PLAN REVIEW SHEET

Date: December 15, 2020

Petition #: RZP 2020-167

Request: MUDD-O

SCHEMATIC  
SITE PLAN  
SCALE: 1" = 30'

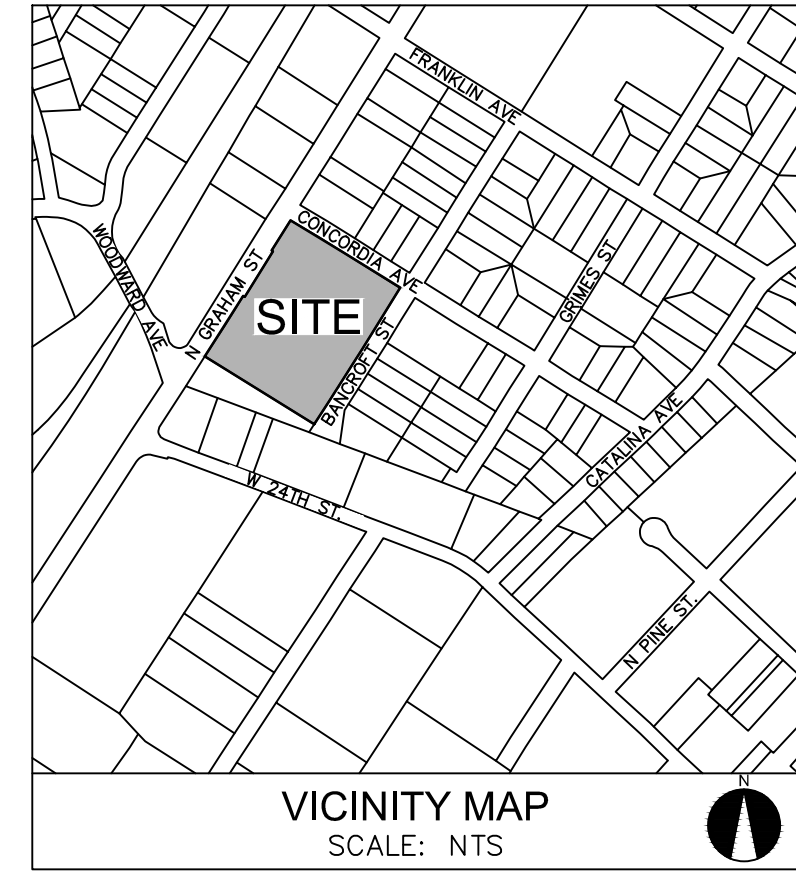
The site is located along CATS local bus route #22 on North Graham Street. CATS requests the petitioner to construct a new ADA compliant bus waiting pad per Land Development Standard 60.01B along North Graham Street for outbound stop #17820. The final location of the pad will be coordinated with the developer through the permitting process.
